National Highways Planning Response (NHPR 21-09) Formal Recommendation to an Application for Planning Permission

Council's Reference: 21/03268/OUT

Location: OS Parcel 2636, NW of Baynards House, Ardley

Proposal: Outline planning permission (all matters reserved except for access) for the erection of buildings comprising logistics (Use Class B8) and ancillary Office (Use Class E(g)(i)) floorspace; construction of new site access from the B4100; creation of internal roads and access routes; hard and soft landscaping including noise attenuation measures; and other associated infrastructure

Drawing Number  
**S1299-P-12**

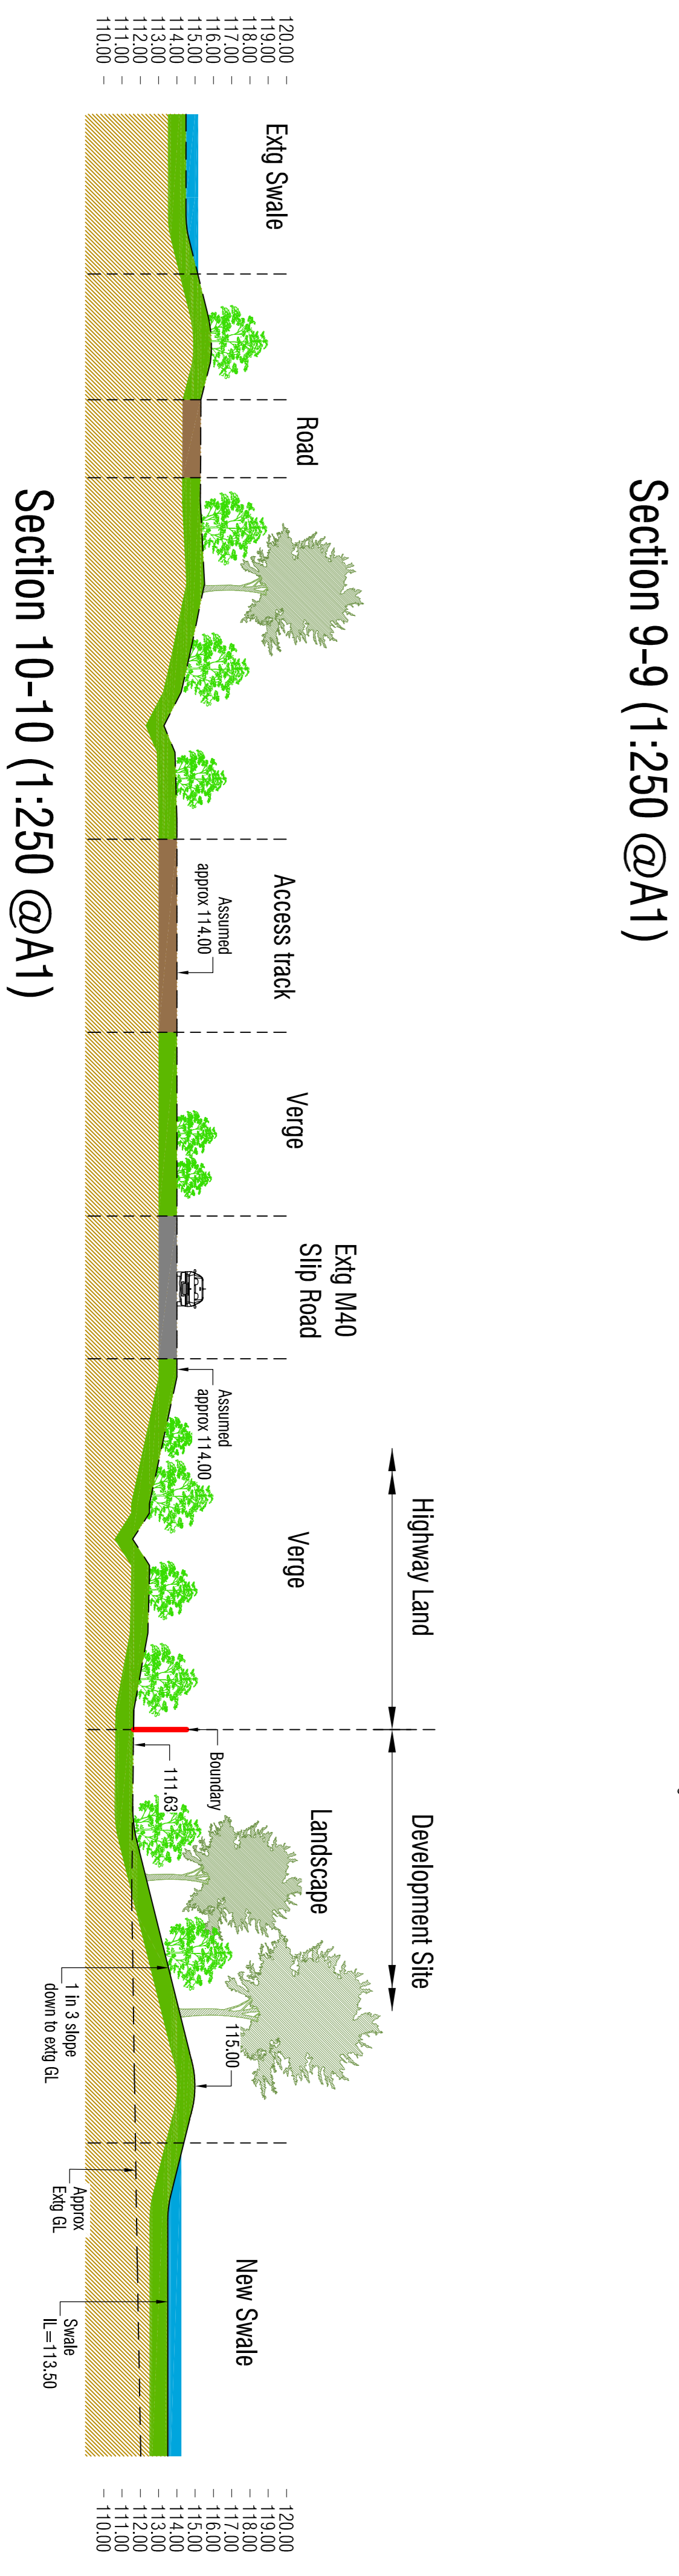
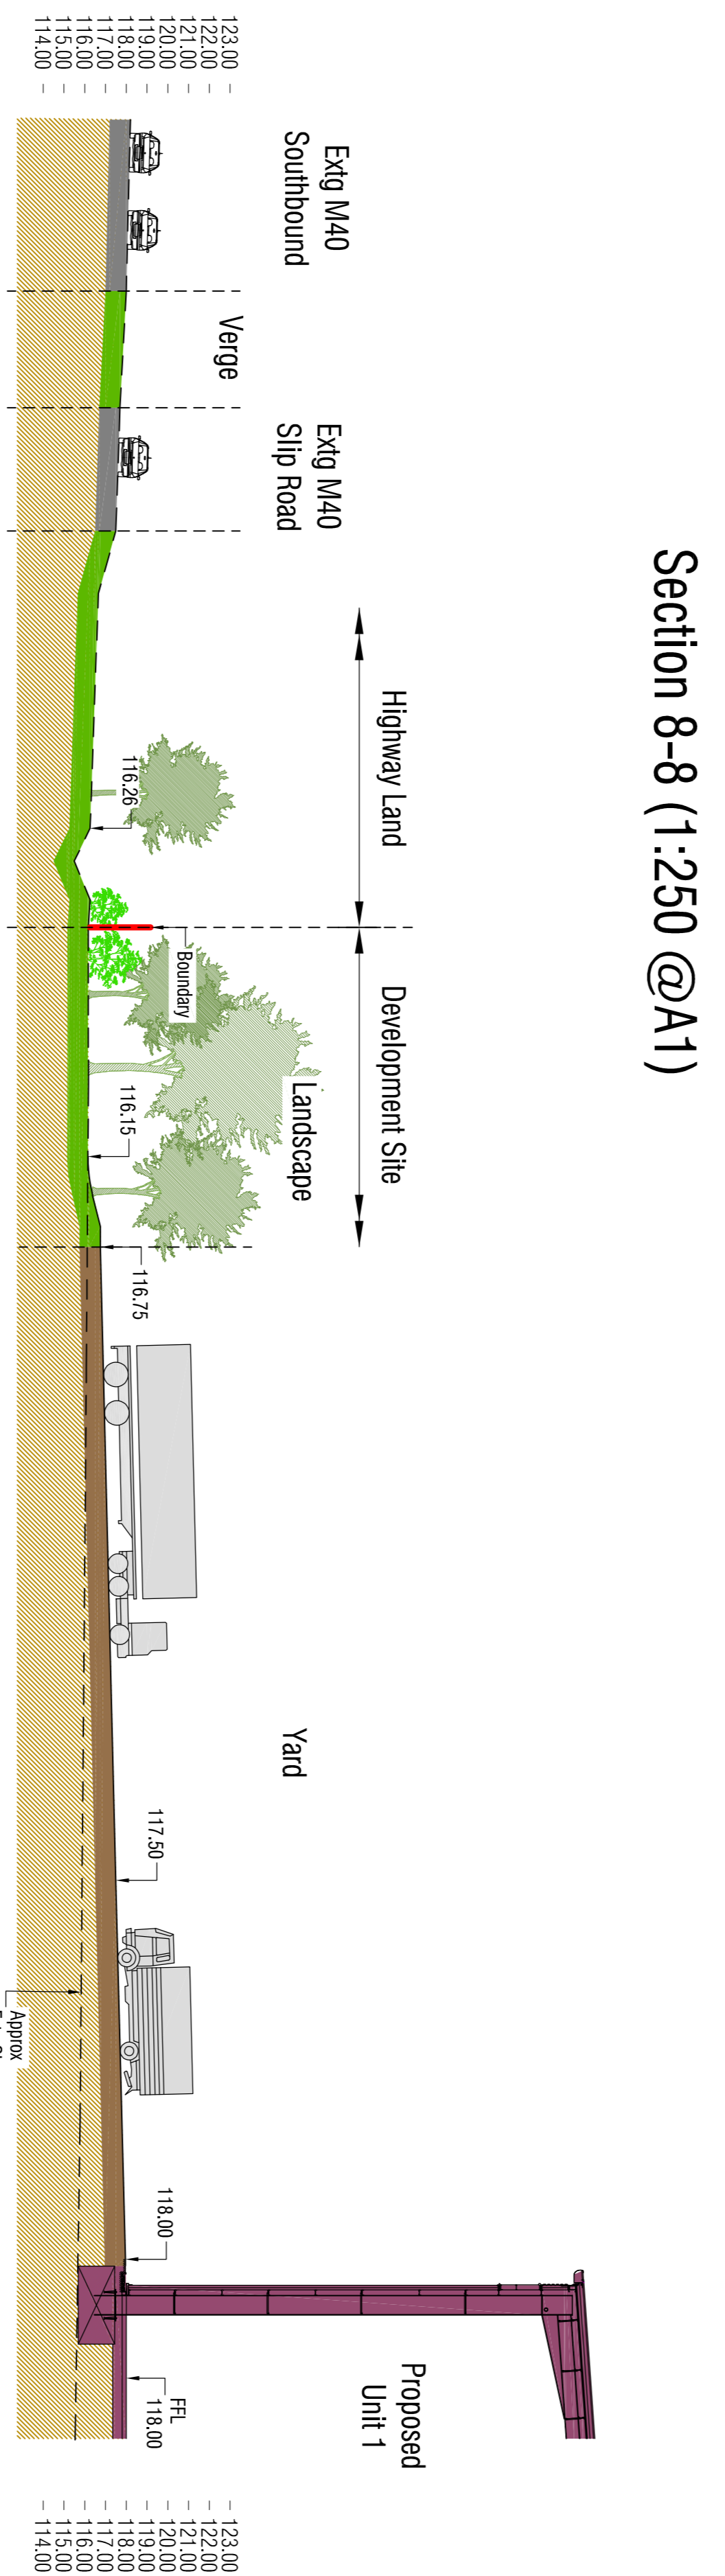
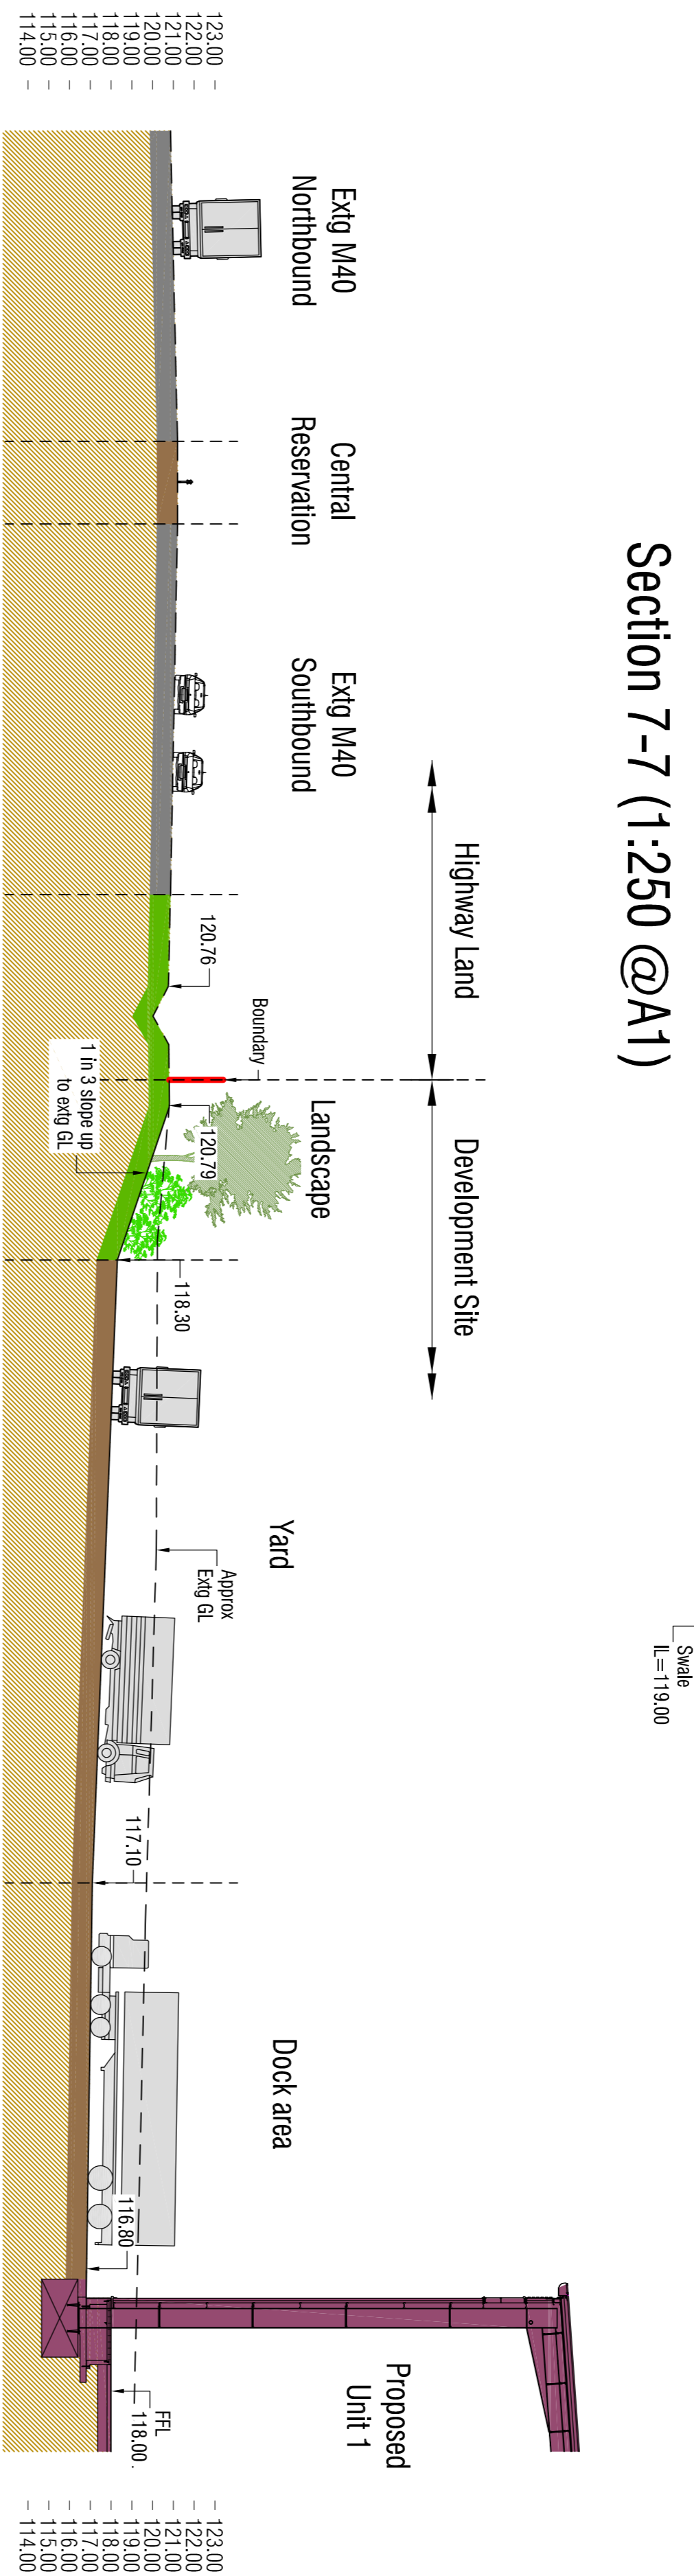
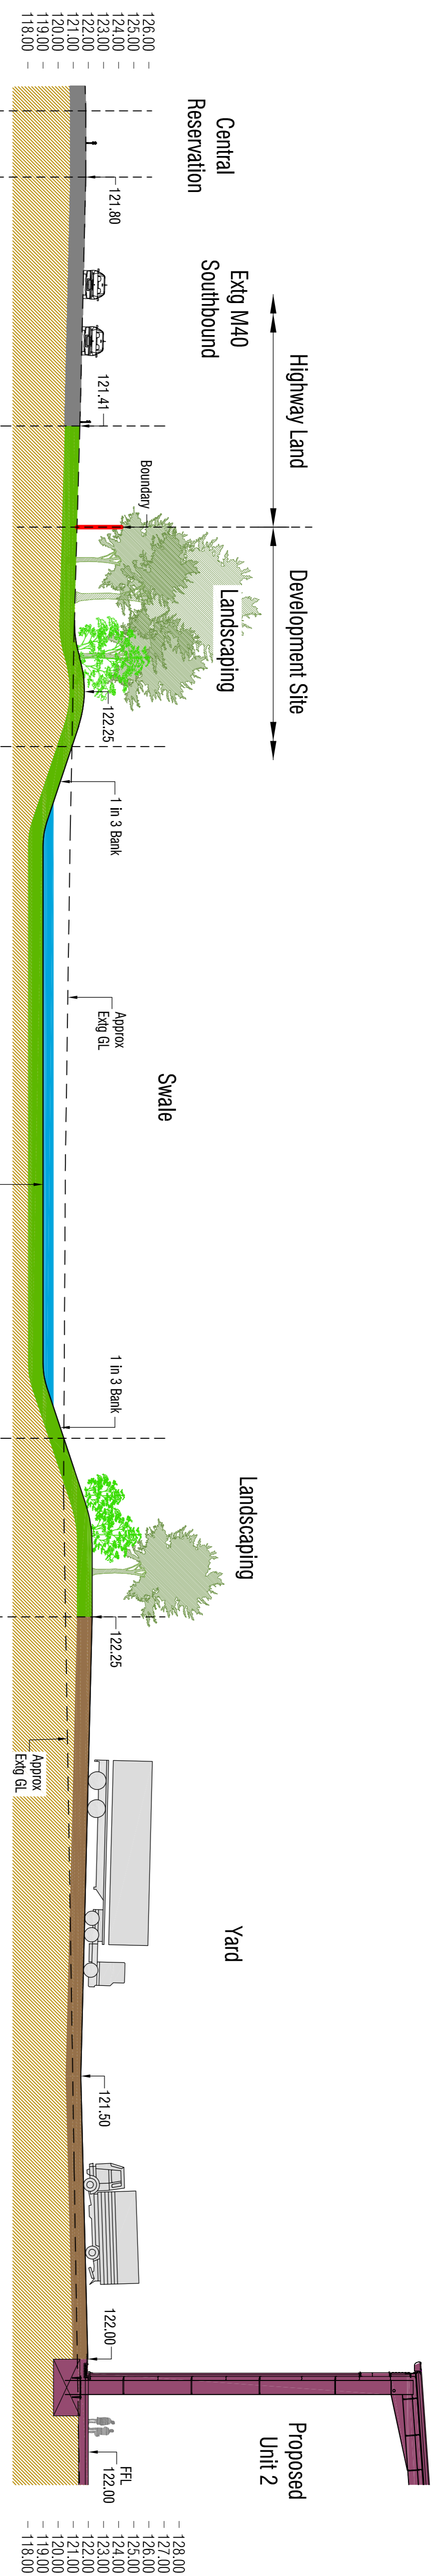
The applicant will need to advise / confirm if there will be any earthworks associated with the development(s) in relatively close proximity to National Highways boundaries (e.g. the stability of the balancing ponds, etc). In the first instance, some cross sections (to scale) through the boundaries showing the proposed extent of the development, its features and any proposed changes in elevation (excavations, landscaping) etc should be submitted for further assessment. Once received, we will review to determine the possible extent of any geotechnical reporting under the Design Manual for Roads and Bridges (DMRB) standard CD 622, which may be required to confirm the extent of any geotechnical risk to the SRN.
